Engineers Comments Regarding Condition 3- Surface Water Drainage Design

APPLICATION **BN/14/19/DOC**
NO:

Registered: 29-MAR-19
Site Address: The Cottage Piggeries Church Lane Barnham PO22 0DB
Description of Works: Approval of details reserved by condition imposed under ref BN/19/18/PL relating to Condition No 3 surface water drainage.

Drawing Number	2014/SK2	Revision	-
----------------	----------	----------	---

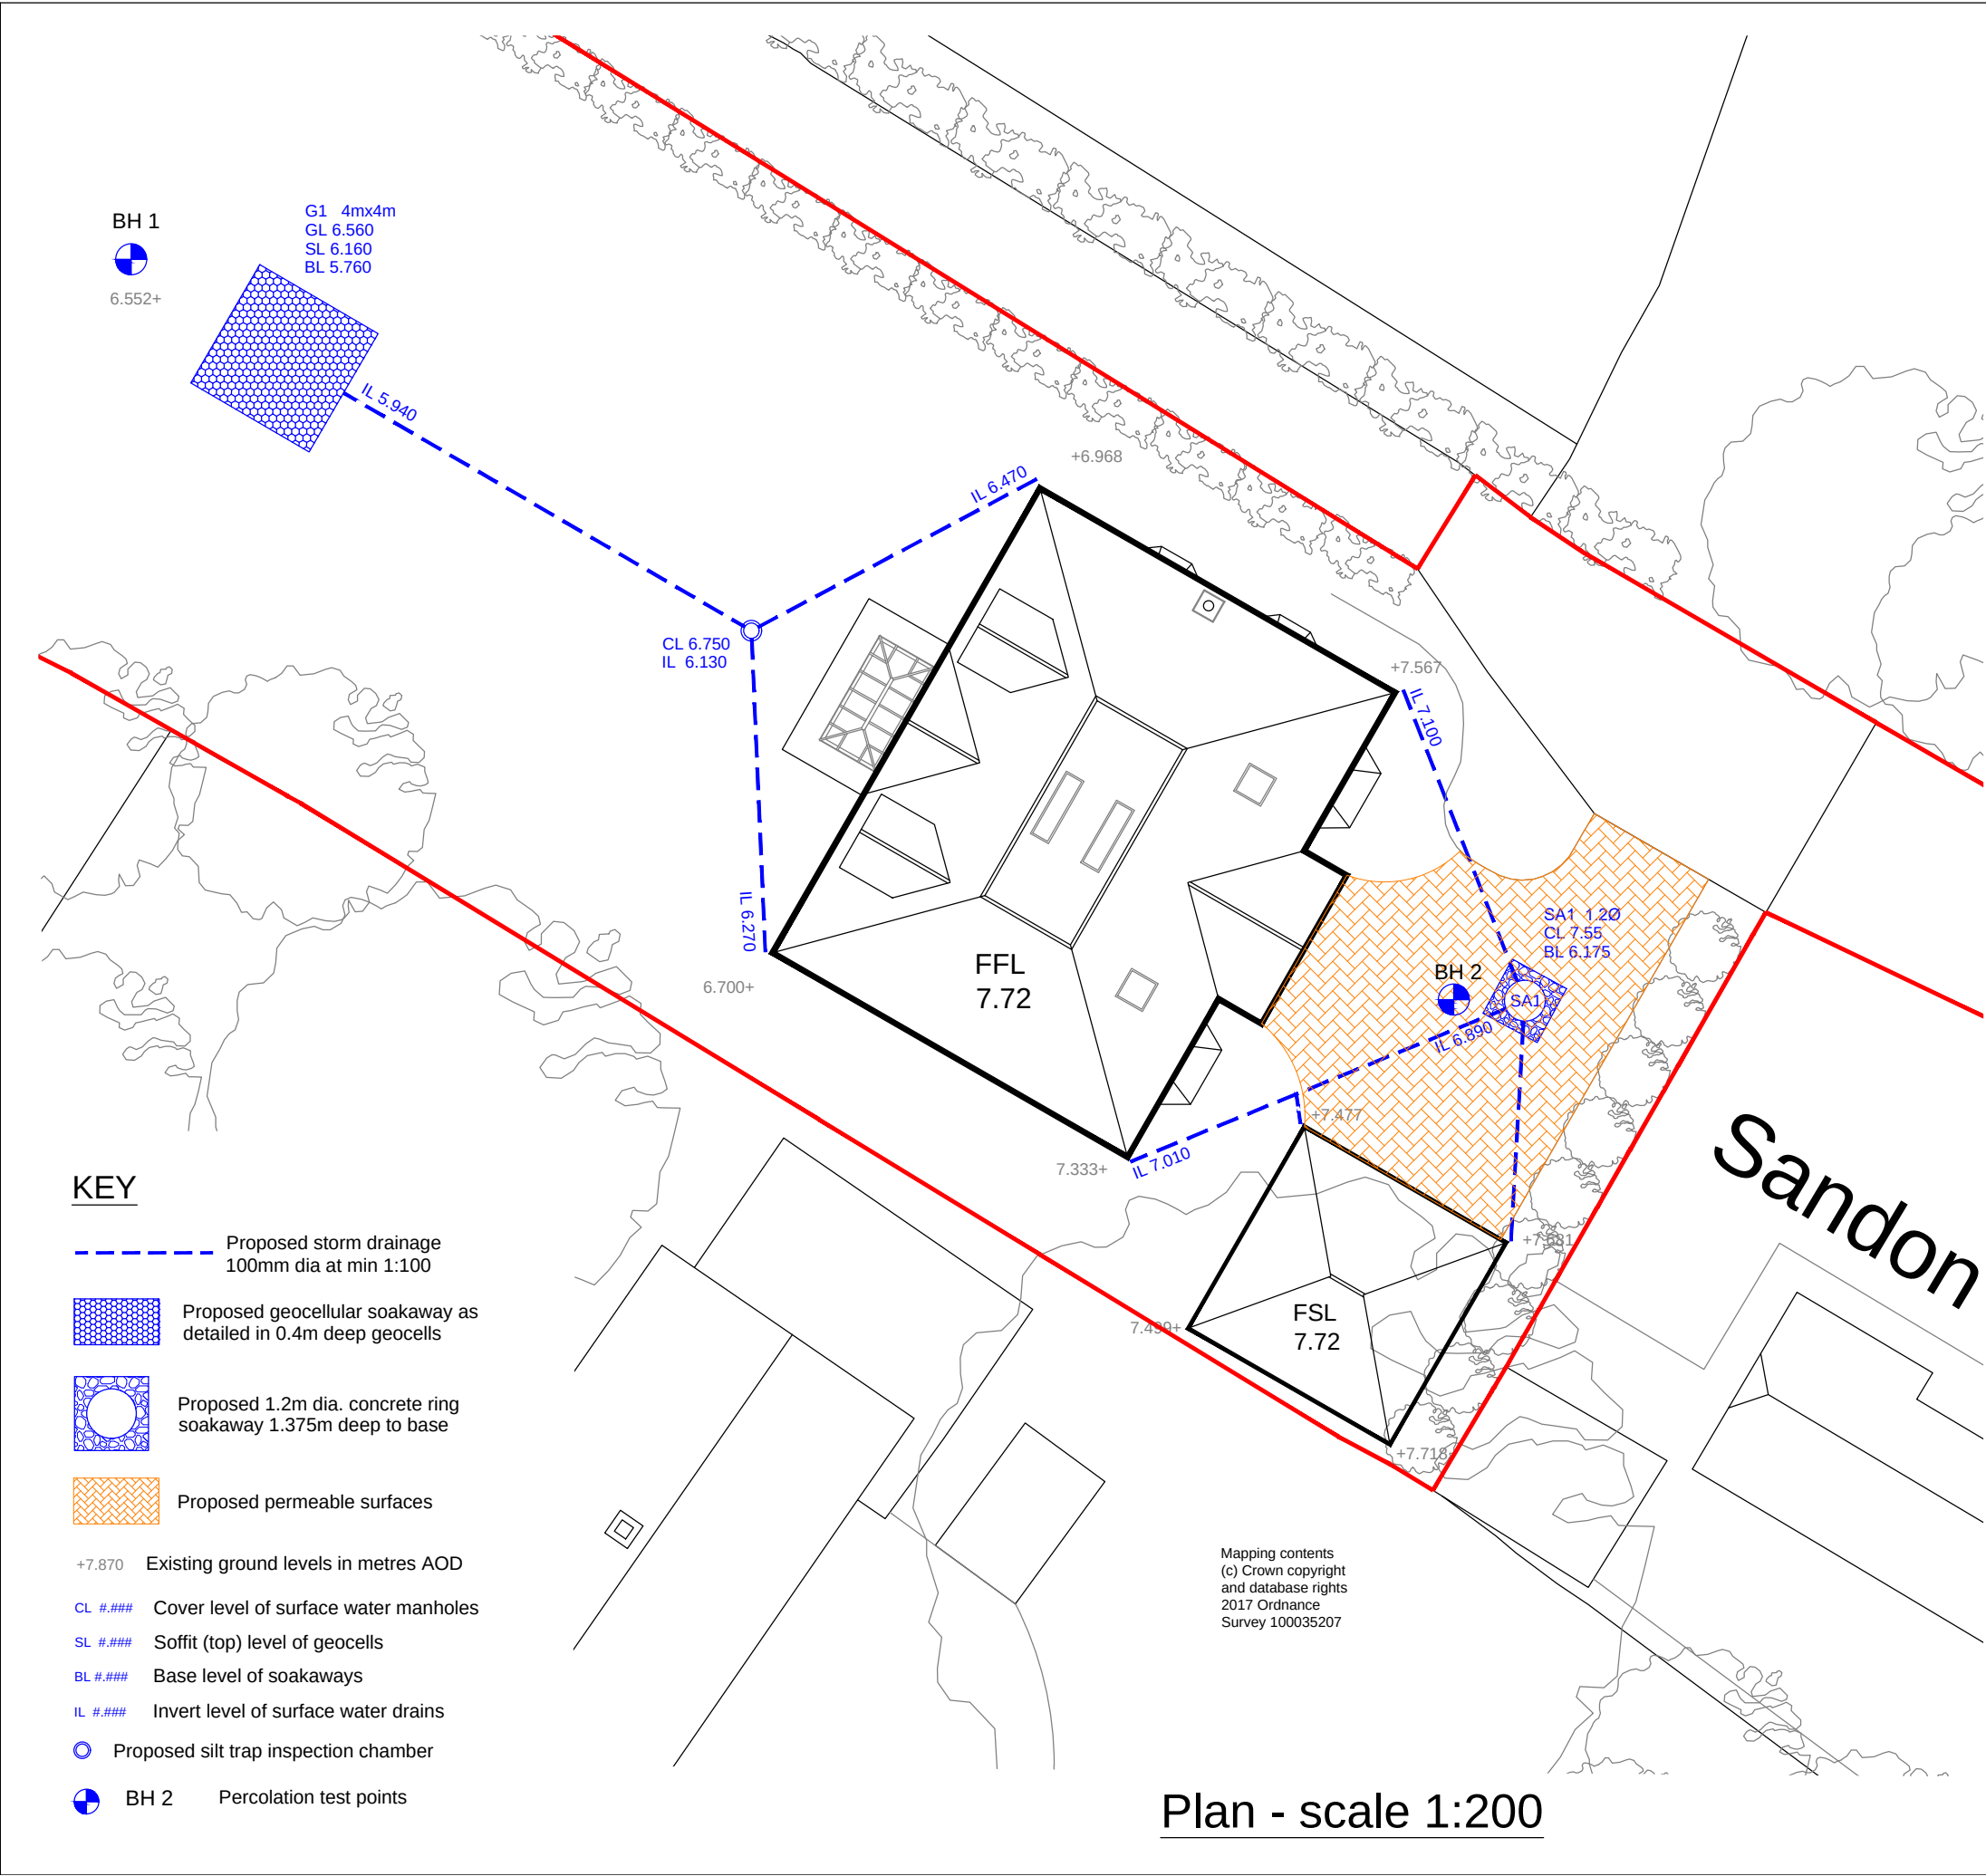
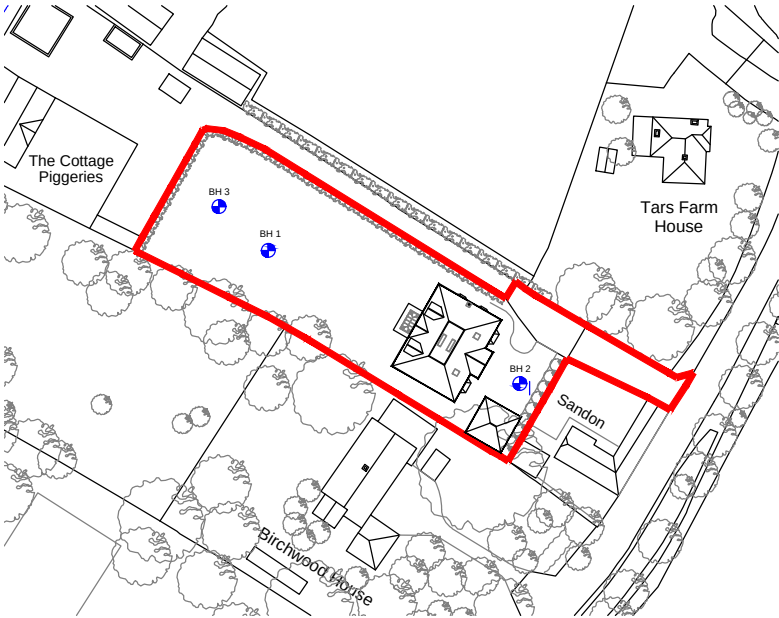
Winter groundwater monitoring and infiltration testing has been completed. The highest groundwater levels encountered were at 0.79m depth. It is unclear at which of the three monitoring locations that this peak occurred. Please can this be confirmed.

The soakaway that is proposed to be located in the rear garden has an invert level of 5.66m (0.9m below ground). The base of this soakaway must be located above the maximum recorded groundwater level, or adequate volume must be provided above the groundwater level.

I have received a revised layout from the client's engineer (attached). The base of the soakaway has been raised so that sufficient capacity is available above groundwater, and the layout now matches the calculations. Based on this revised drawing, and the previously submitted calculations and details I am happy to recommend the discharge of condition 3.
